CITY OF ALBUQUERQUE

November 16, 2018

**RE: Apartment Urban Living @ Nob Hill
Central and Montclair NE
Conceptual Grading Plan Stamp Date: 11/12/18
Drainage Report Stamp Date: 10/29/18
Hydrology File: K17D073**

BUBBLE-UP OUTLET

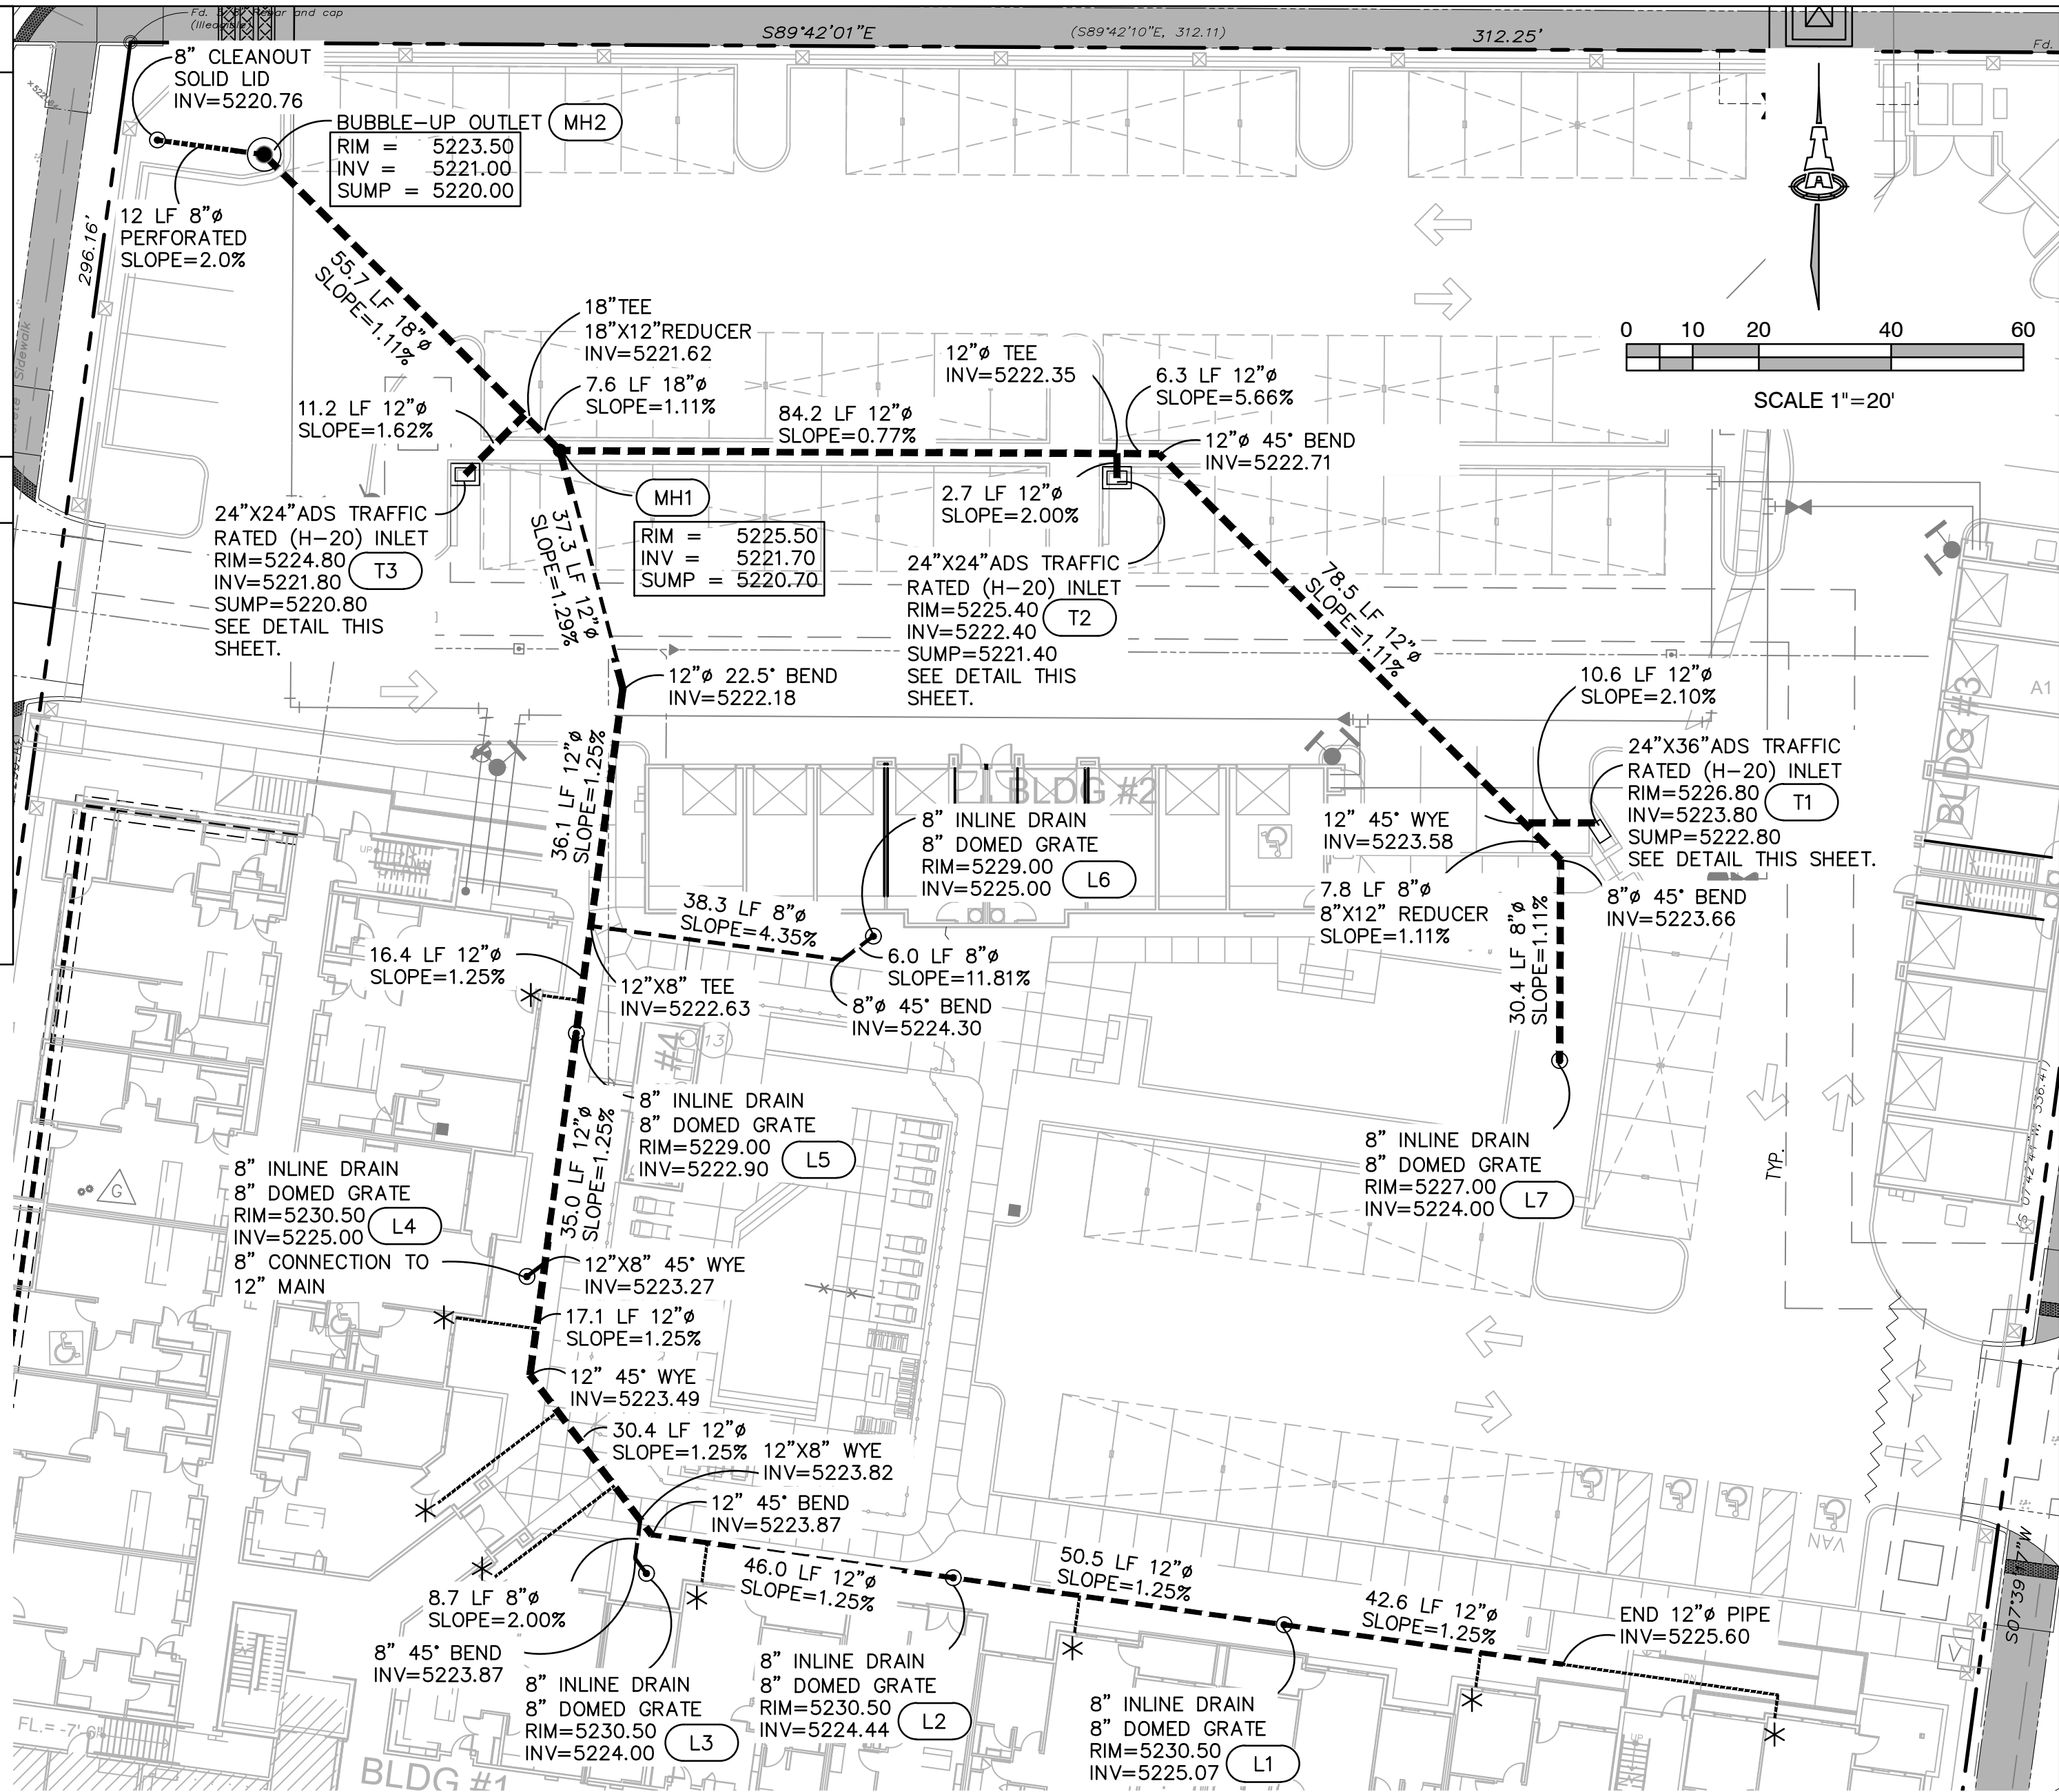
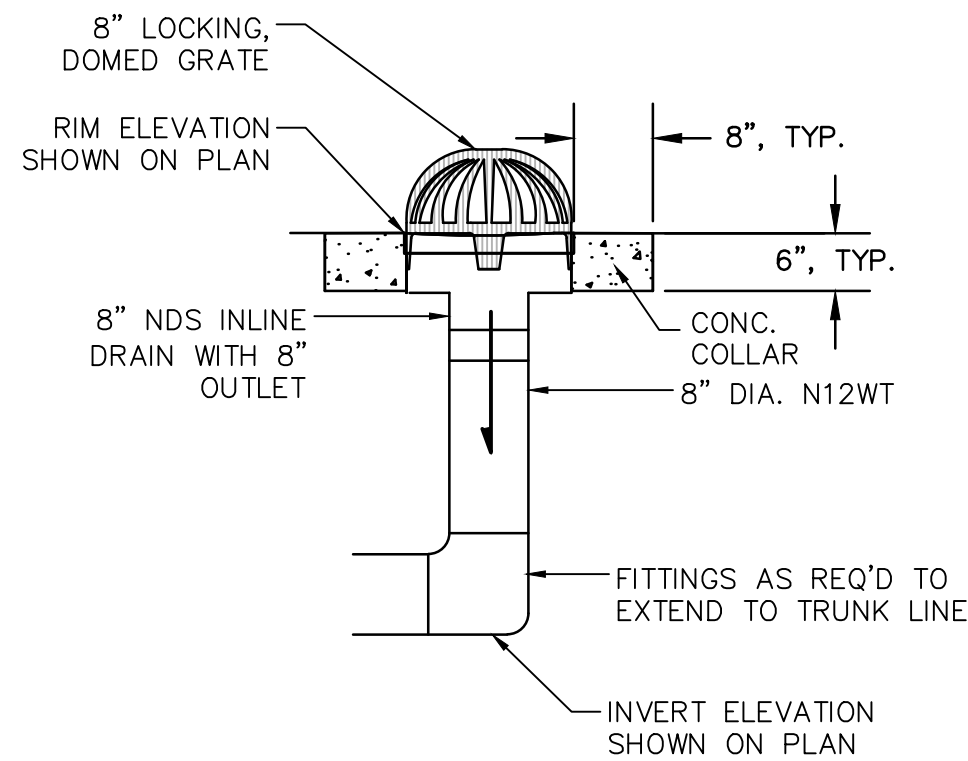
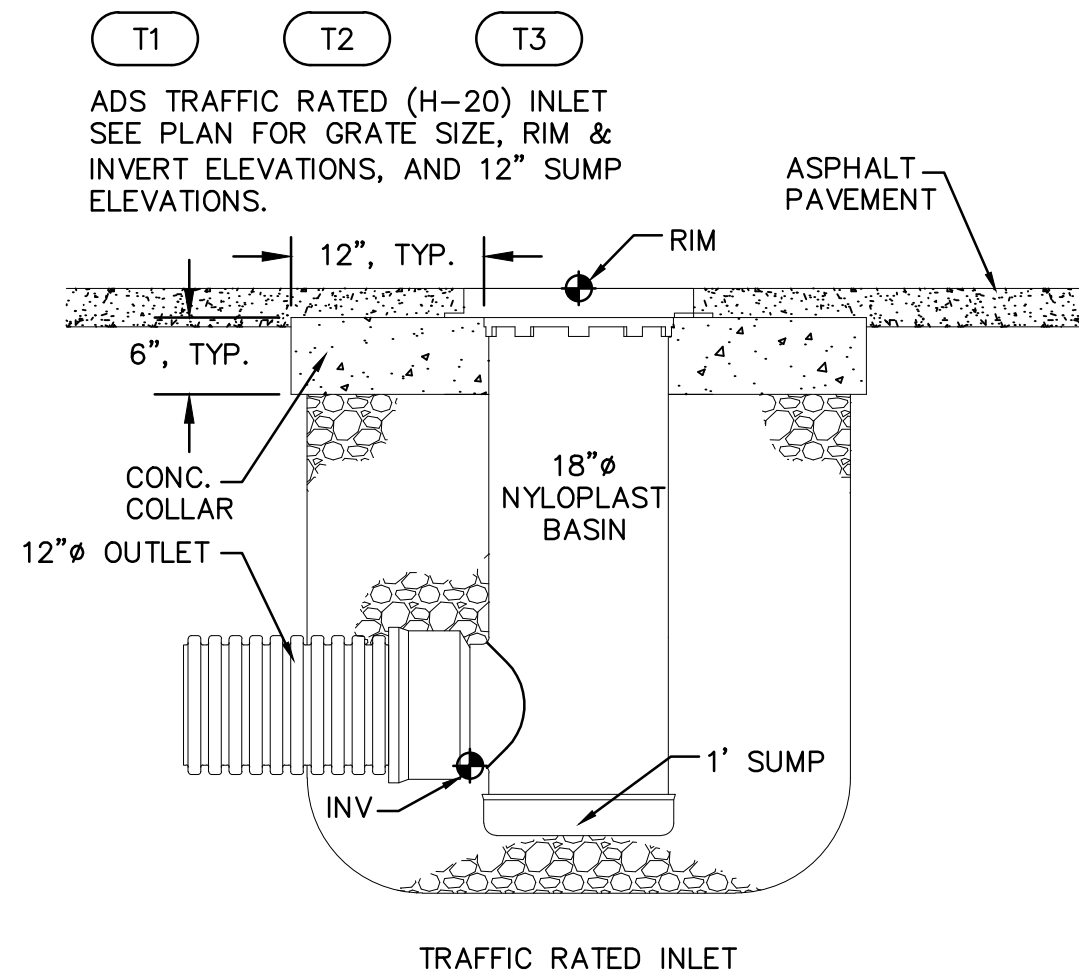
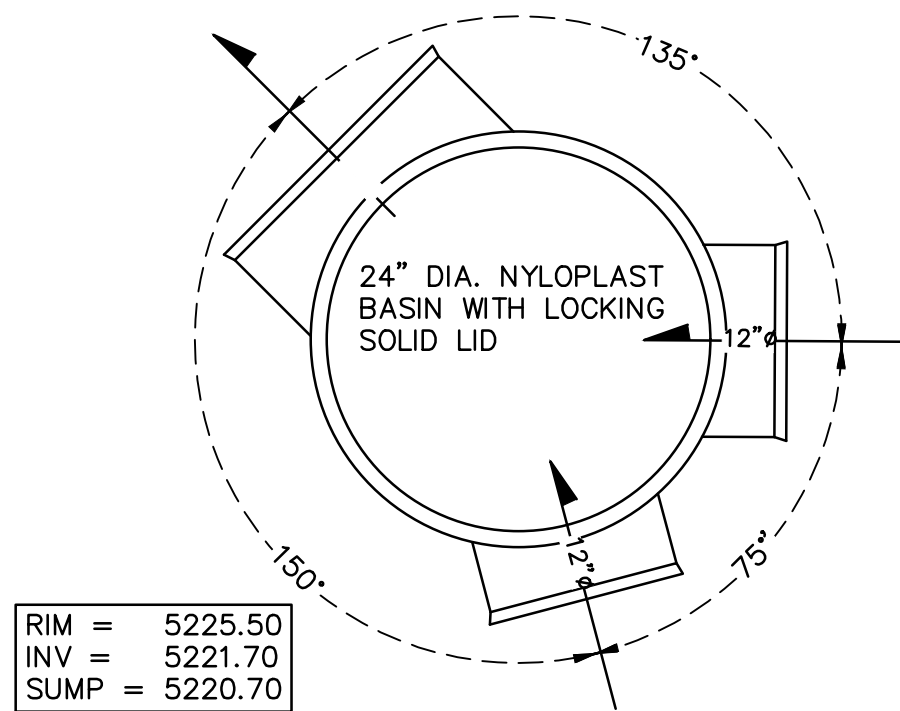
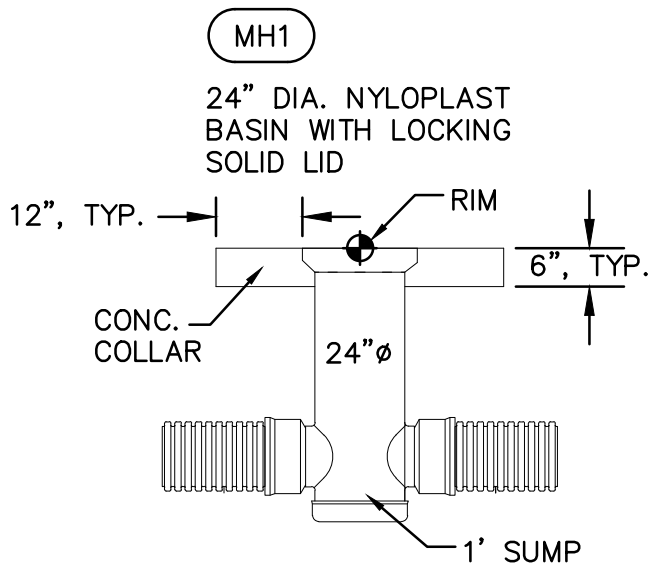
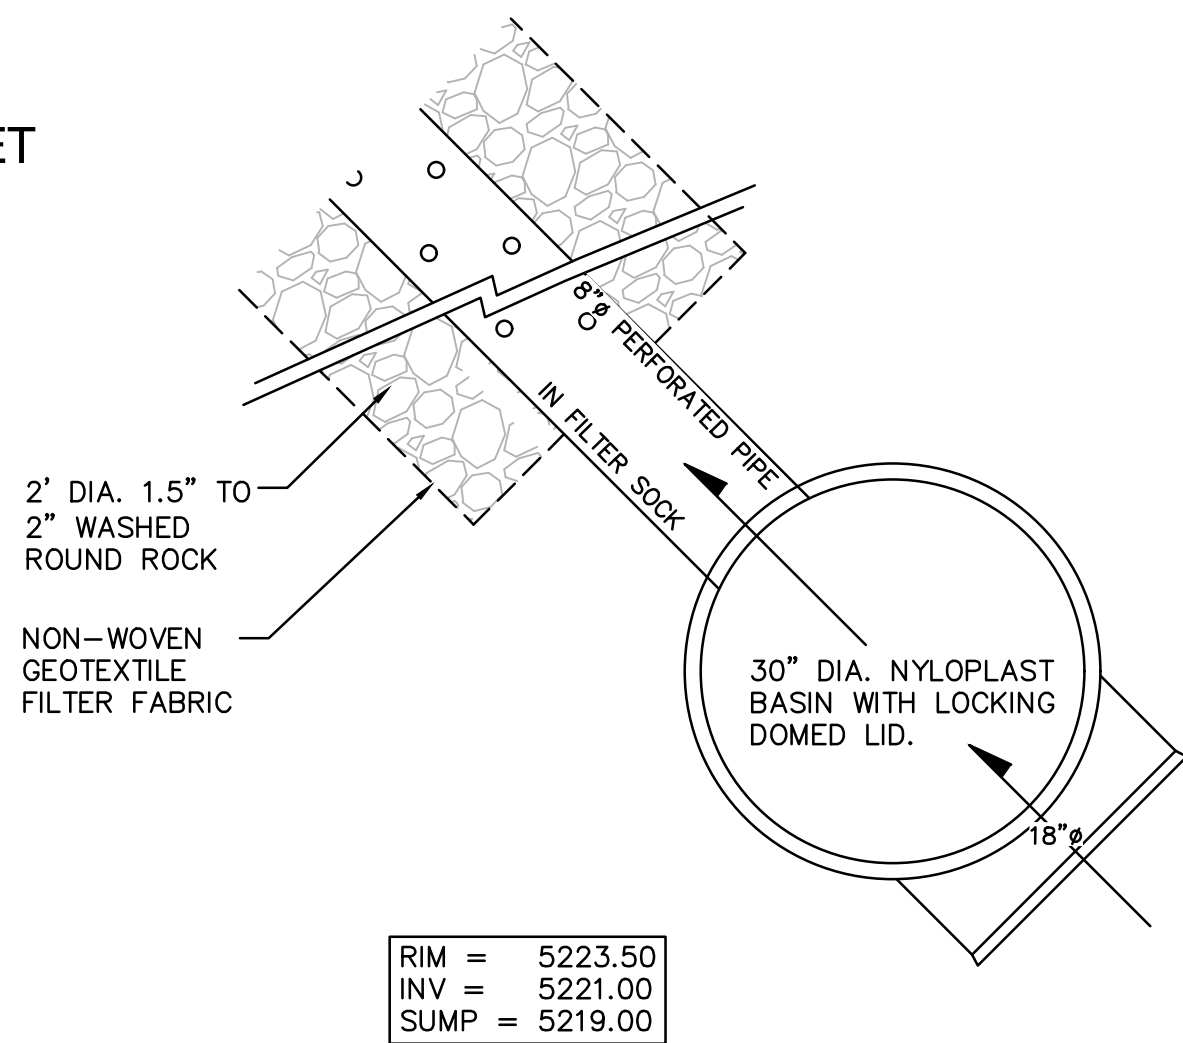
4. Remove all "Conceptual" markings.
5. Provide Hydraulic Calculations per DPM 22.3 documenting:
 - a. Inlet and pipe capacities, including 2x capacity for inlets in sump condition or a suitably sized overland flow path and profiles and HGL calculations.

- b. Pond rating curve and routing of the 100-yr event. Also show the 100-yr water surface on the grading plan.
 - c. The HGL calculations need to use the maximum water surface elevation above the bubble-up grate as the downstream starting EGL.
